08 NOV 2011

Martin Nugent
01254 828060
D3/11/0675

**Planning Application, Ribble Valley District
3/11/0675 Aspinalls Farm, Kenyon Lane, Dinckley**

Proposed Site Plan 1:500

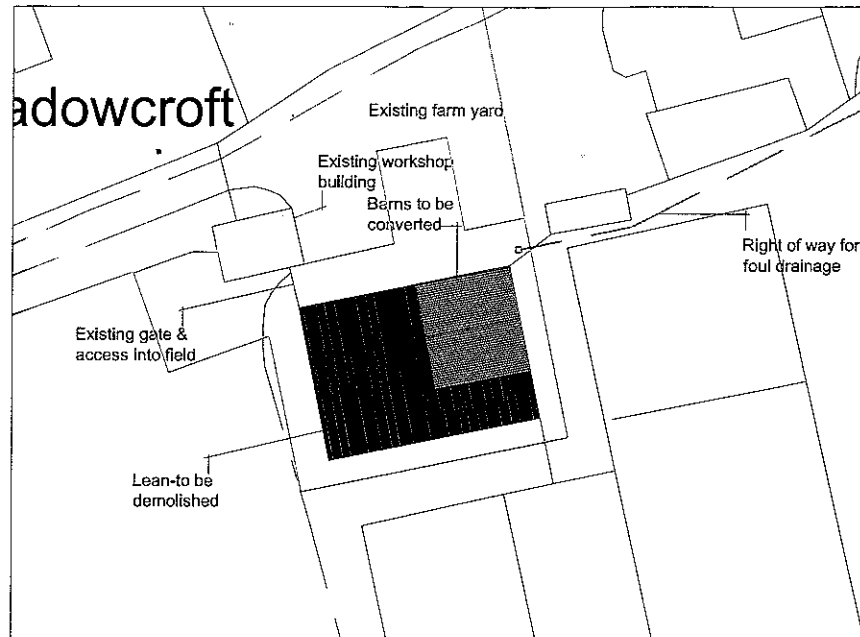
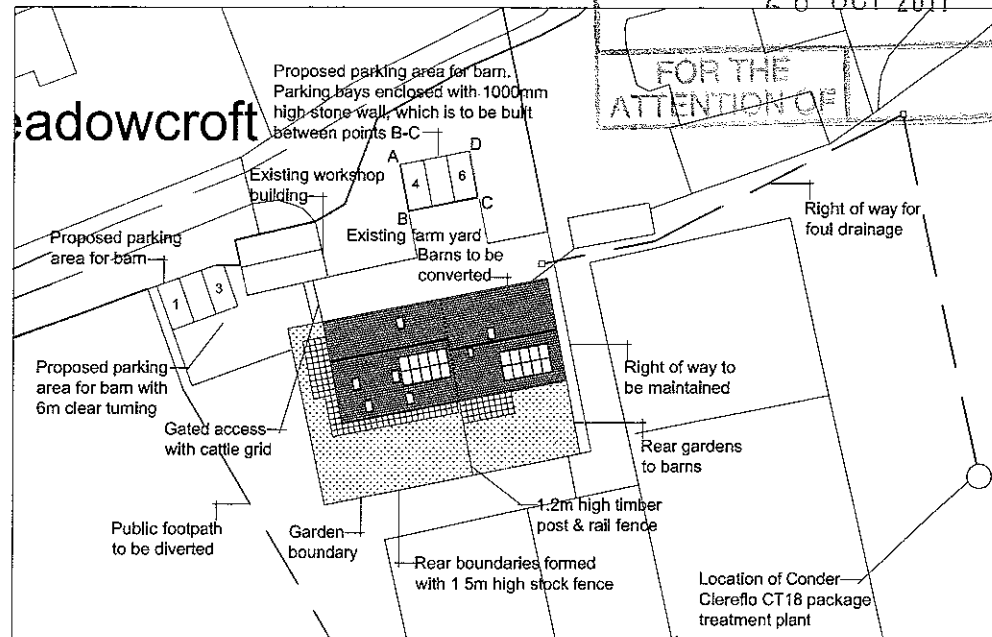
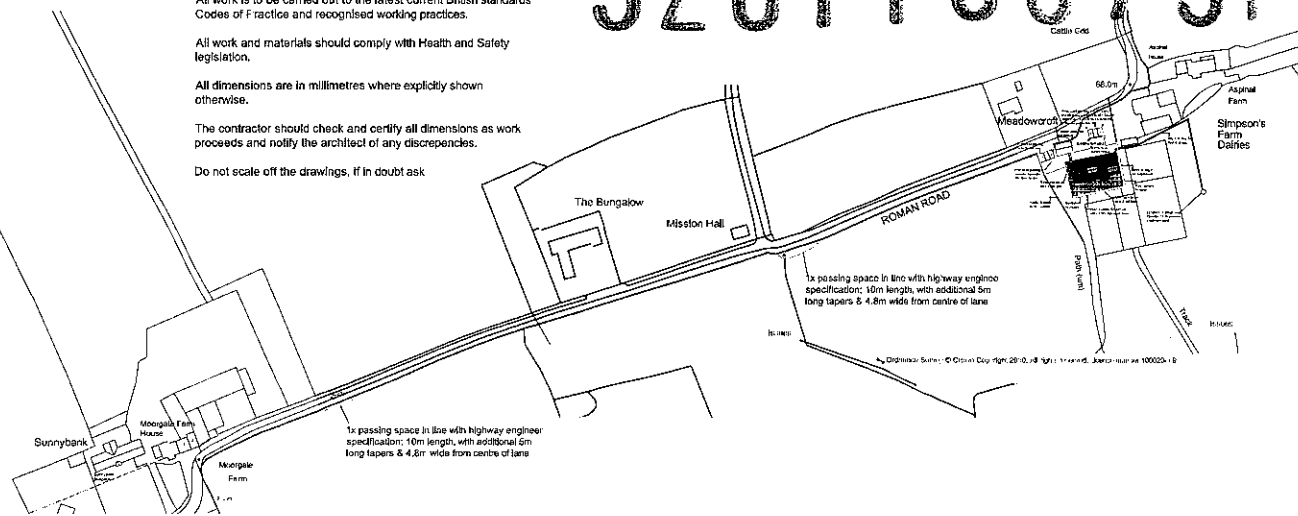
The site plan identifies two locations where parking is provided for three vehicles. I am satisfied that this level of provision is adequate for the operation of the proposed residential properties and that the location of the bays has a neutral impact on the safe movement of agricultural vehicles.

On the site plan submitted, the red edge identifies the proposed areas of residential development. This includes the parking bays and the relevant areas for manoeuvring to and from these spaces. I would recommend that the proposed wall for the three parking spaces within the yard is repositioned. With the wall placed to the property side of the bay, there is less likelihood of other vehicles parking along the "open" of the bay and potentially obstructing passing vehicles.

The design of the bay within the yard and to the north of the proposed residential development should be the subject of an amended site plan, with the layout to be agreed prior to consent being granted. If this is not secured, then a further condition would be required.

In order to secure the means of access through the yard area, the layout should be introduced as shown on the amended plans. This will insure that the movement of through traffic and of vehicle moving to and from the adjacent agricultural areas is maintained at all times.

Finally, the function of the access track serving the existing agricultural sites and residential properties on Moorgate Lane, as it continues from Kenyon Lane, requires the provision of two suitably located and constructed passing places. There was a

1. That two passing places be introduced on Moorgate Lane, between Aspinalls Farm and Moorgate Farm, to be of minimum dimensions, length 10m, incorporating 5m tapers and of width 4.8m from the centre of the lane.
